XQLA LVIA Review

Land South of Barugh Green Road and East of Higham Common Road, Barnsley (Barnsley West)

5th February 2024 – Landscape notes on ES/Chapter 6 (LVIA)

Figure 4: Parameters Plan

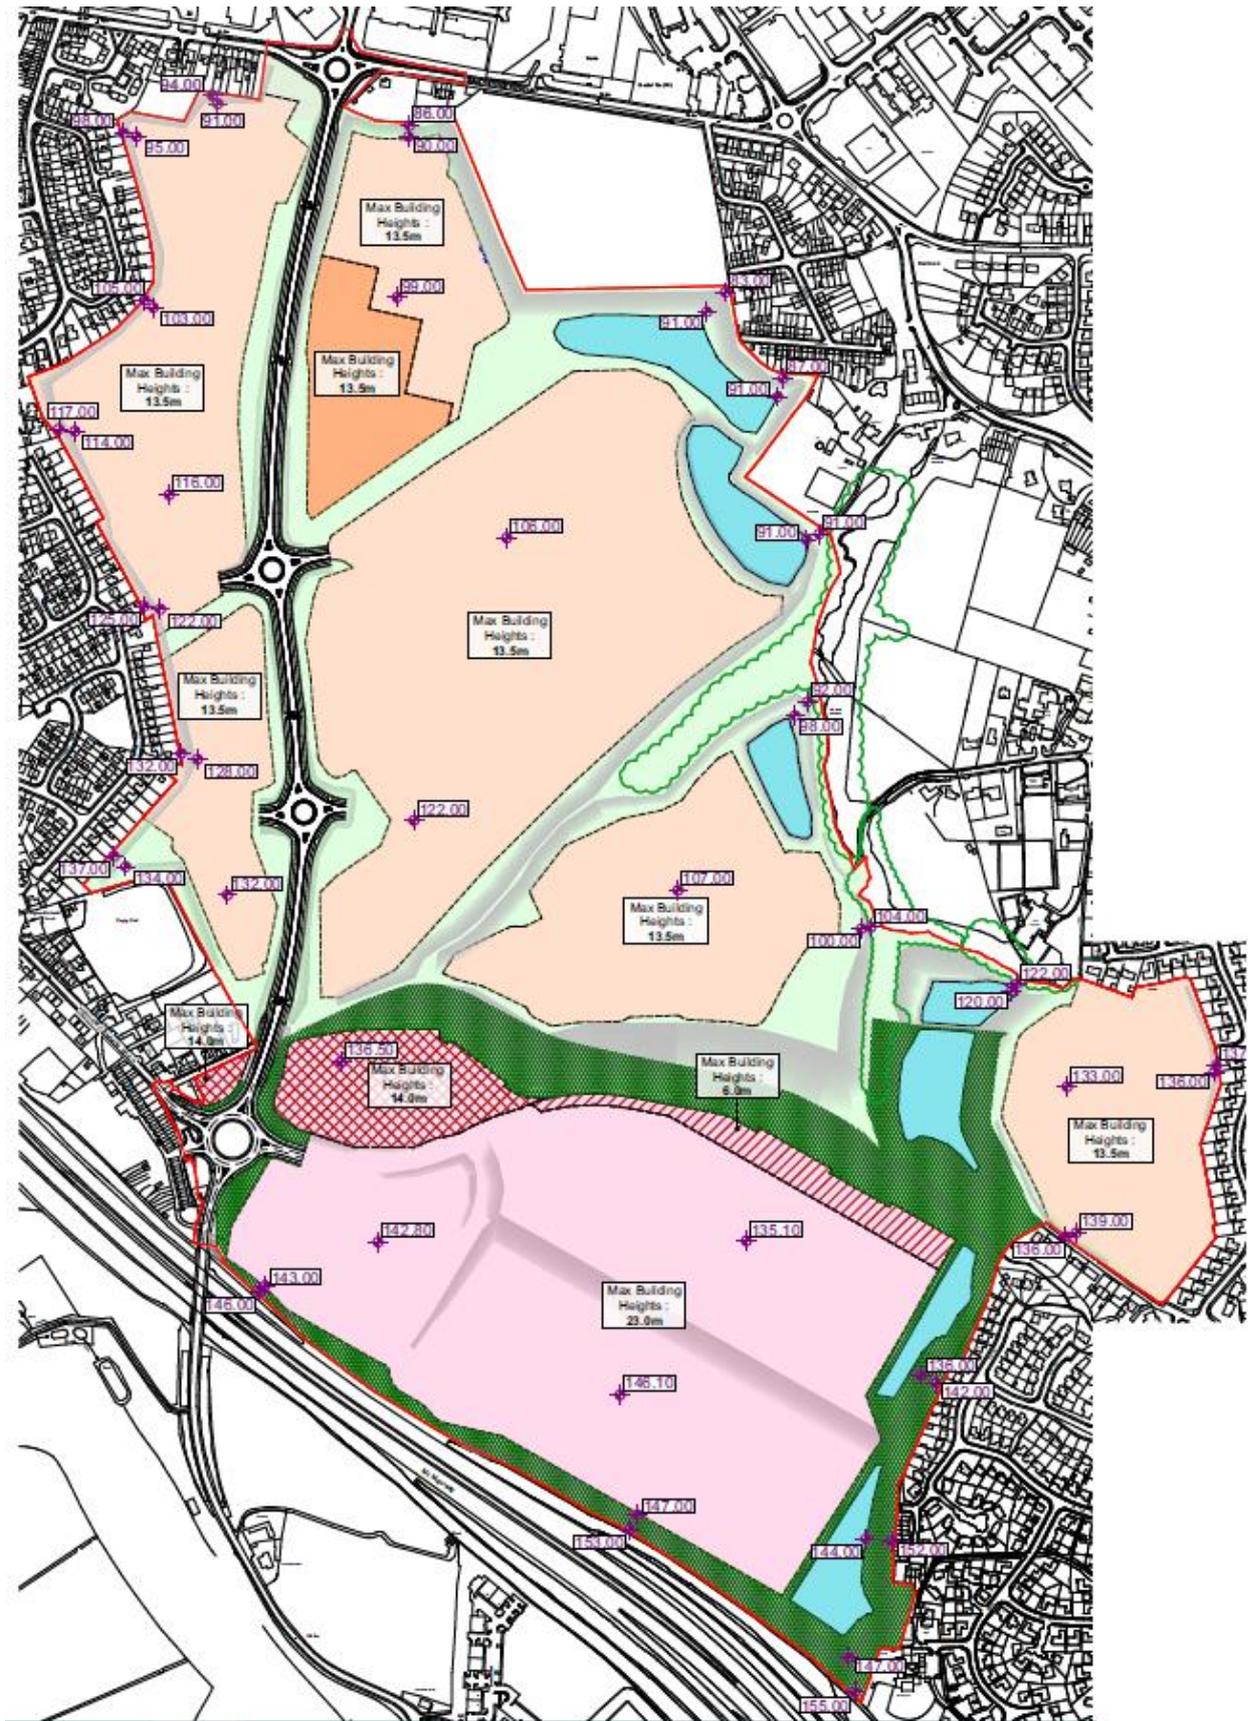
Site levels raised by about 0.5-1m for Employment Allocation; adjustment to massing strategy (23m down to 18.5/16.3m).

Building height at the roundabout junction of Higham Common Road and Hermit Lane lowered to 8.3m from 14m.

Site level for the northern residential block (to the east of the proposed link road) lowered by 5m.

Site level for the residential blocks (to the west of the proposed arterial road) raised by 1-3.5m.

Site level for the residential block along south eastern fringe of the development area raised by a metre.

With reference to the Parameter Plan betterment has been made in terms of massing with maximum building heights reduced, a revised levels strategy which is closer to the existing site levels, and building lines set further back from key receptors (tbc). Significant betterment is also achieved in terms of green corridors East/West through the residential areas which will serve to break down the grain of the development when viewed from the north and northeast. However the fact remains that the 'bulkiest' massing is located at the

high point of the site in close proximity to residential neighbourhoods in Pogmoor and Higham.
